OFFICE ADDITION FOR:
BLAZER ELECTRIC SUPPLY COMPANY
 6125 OMAHA BOULEVARD
 COLORADO SPRINGS, COLORADO

DRAWING NO.
SP-1

17 SITE PLAN

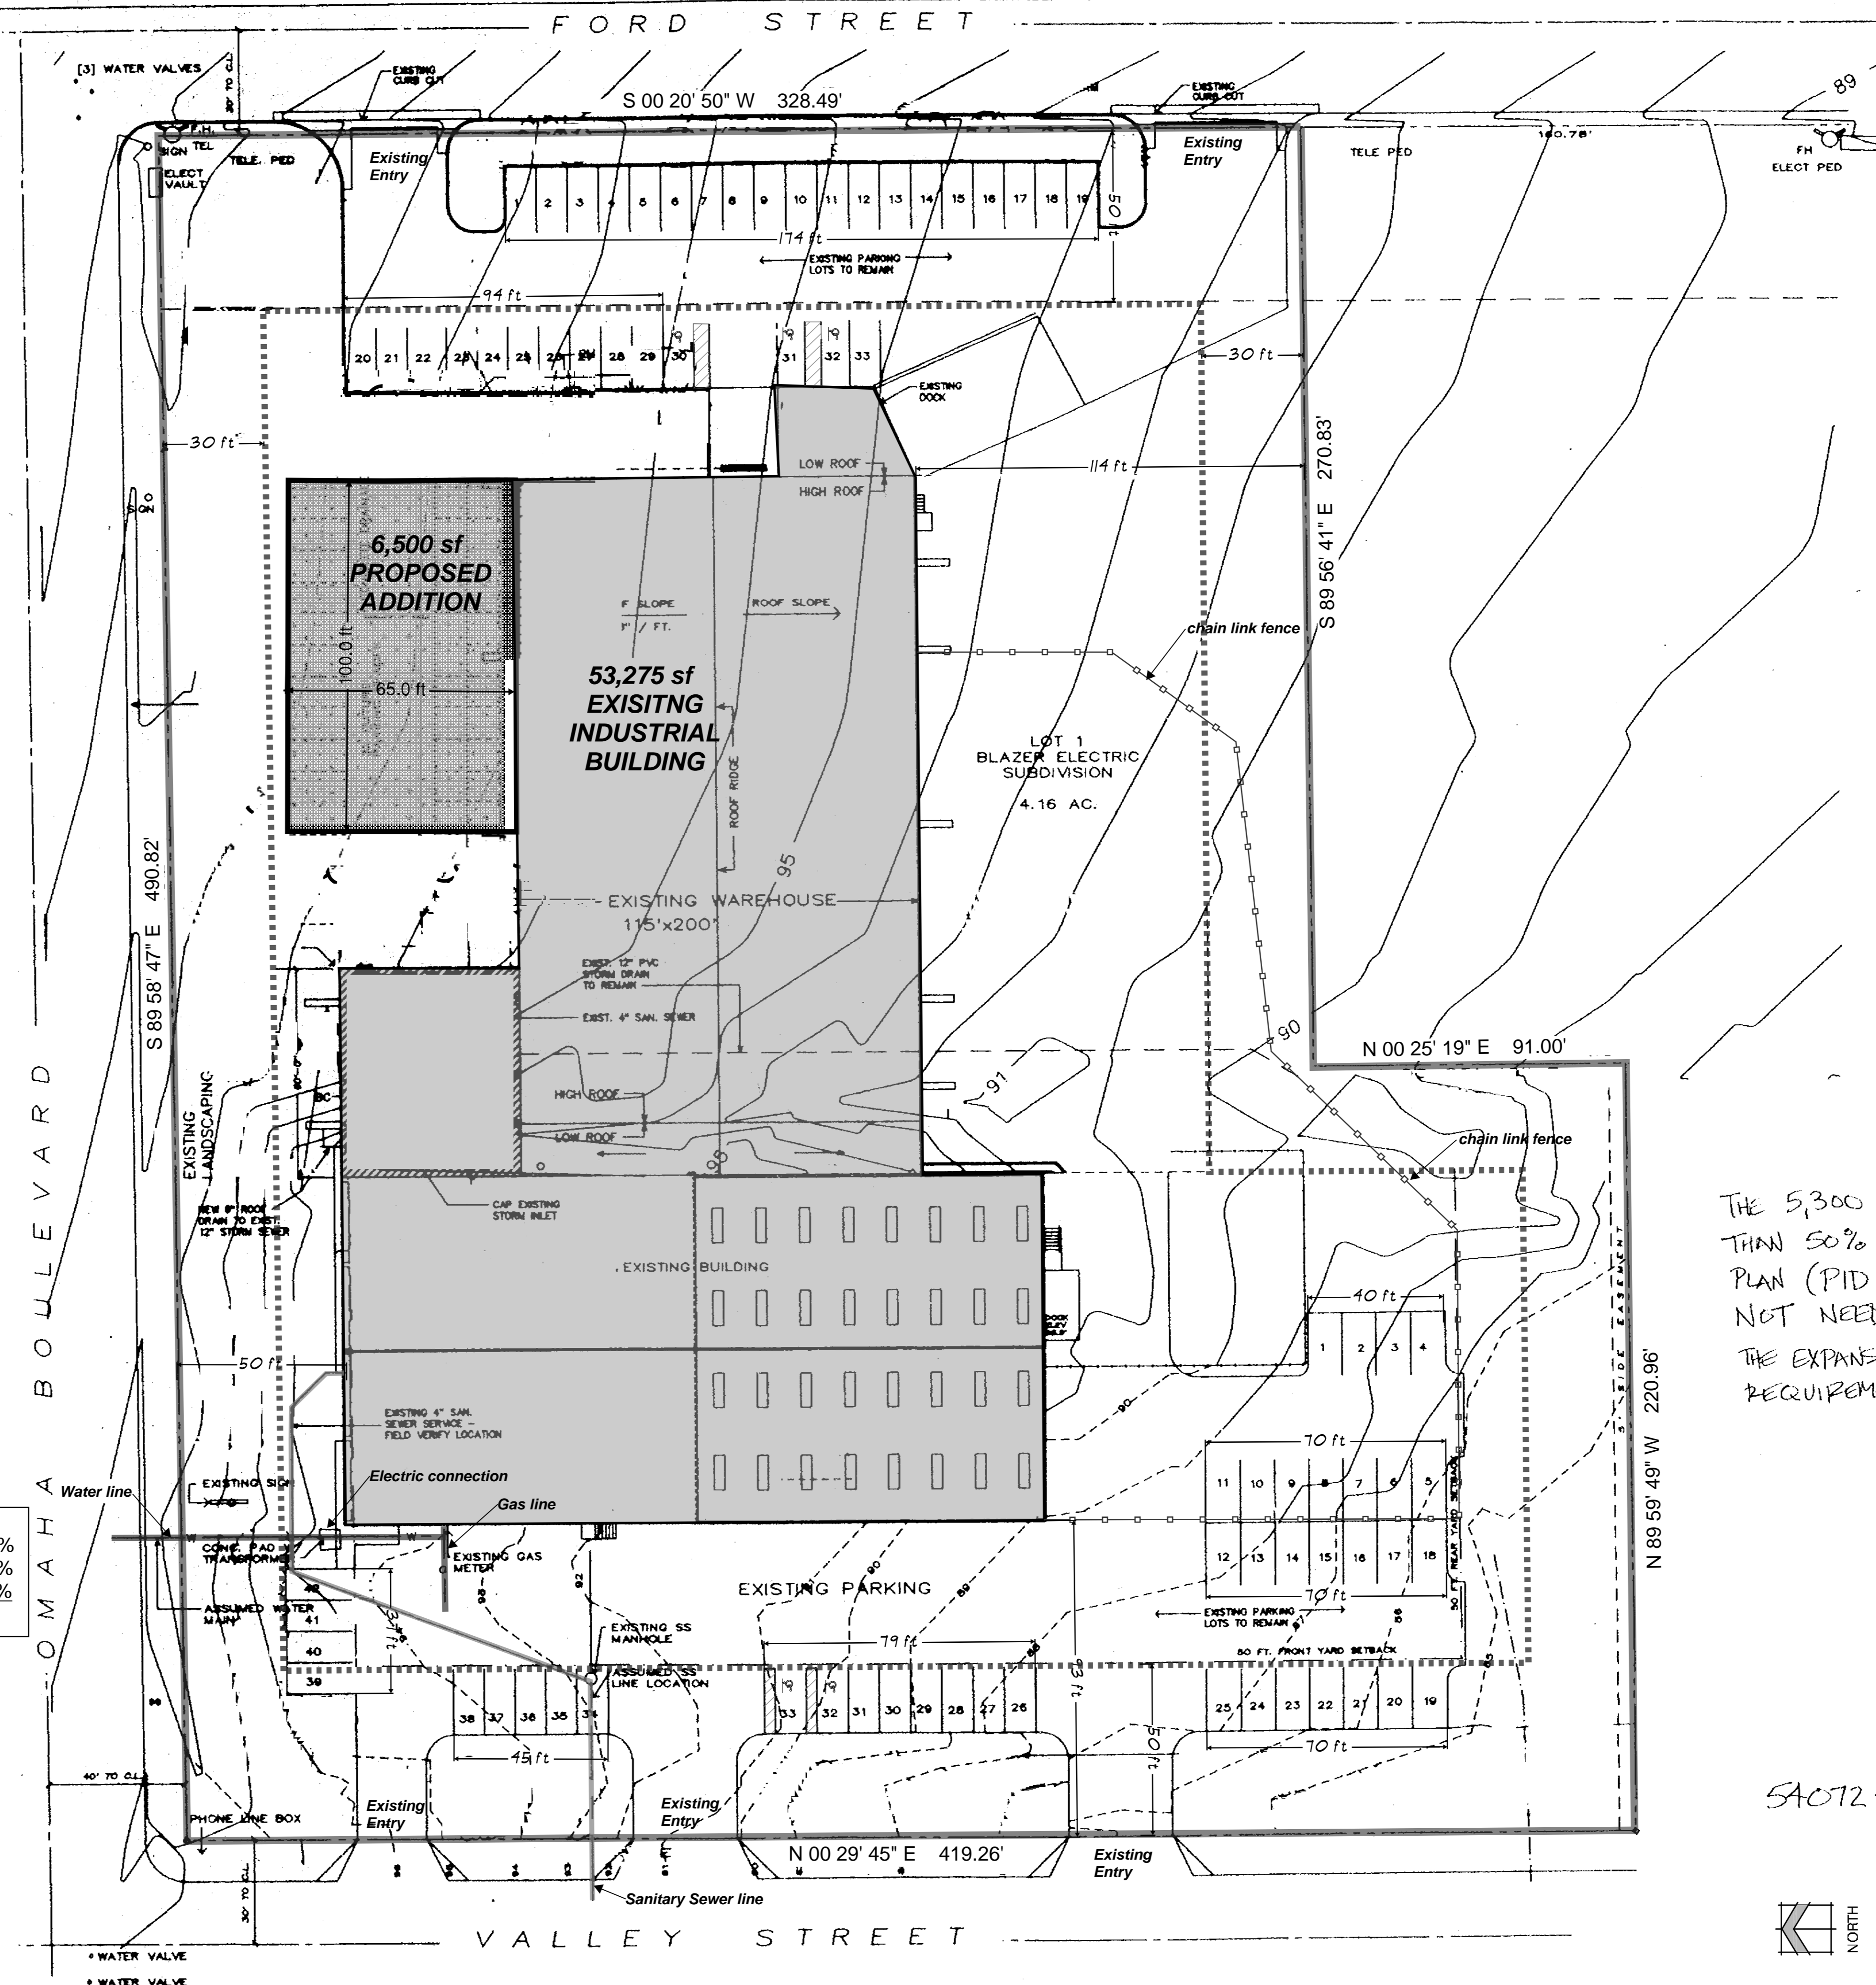
Please add the following items to this site plan:
 Date, north arrow, and a graphic scale
 Location of the property lines, right-of-way, and all existing and proposed easements
 The building footprint for all structures depicted and labeled to include the proposed use(s), floor area, and height. The setbacks of all building footprints dimensioned from all property lines.
 Location and width of all sidewalks
 Location and height of all fences, walls, or berms
 Location and dimensions of all existing and proposed signs
 Traffic circulation including all points of ingress/egress into the property
 The layout and location of all off-street parking, loading and other vehicular use areas
 Location of all ADA parking spaces, ramps, pathways, and signs
 Location, height and intensity of all outdoor illumination
 Location of existing and proposed water and wastewater infrastructure, including well(s) and septic system(s)

Location of all no-build areas, floodplain(s), and drainage facilities
 Location and screening of all dumpster(s) and loading dock areas
 Standard details of parking (compact, ADA, standard), ADA ramps, driveways, and signs
 Location of all existing and proposed utility lines and associated infrastructure
 Existing/proposed land use, parcel size, and zoning
 Percent of open space, landscaping, and lot coverage

We prefer that you remove details from site plan not relevant to request (vegetation) as it makes the site plan difficult to interpret
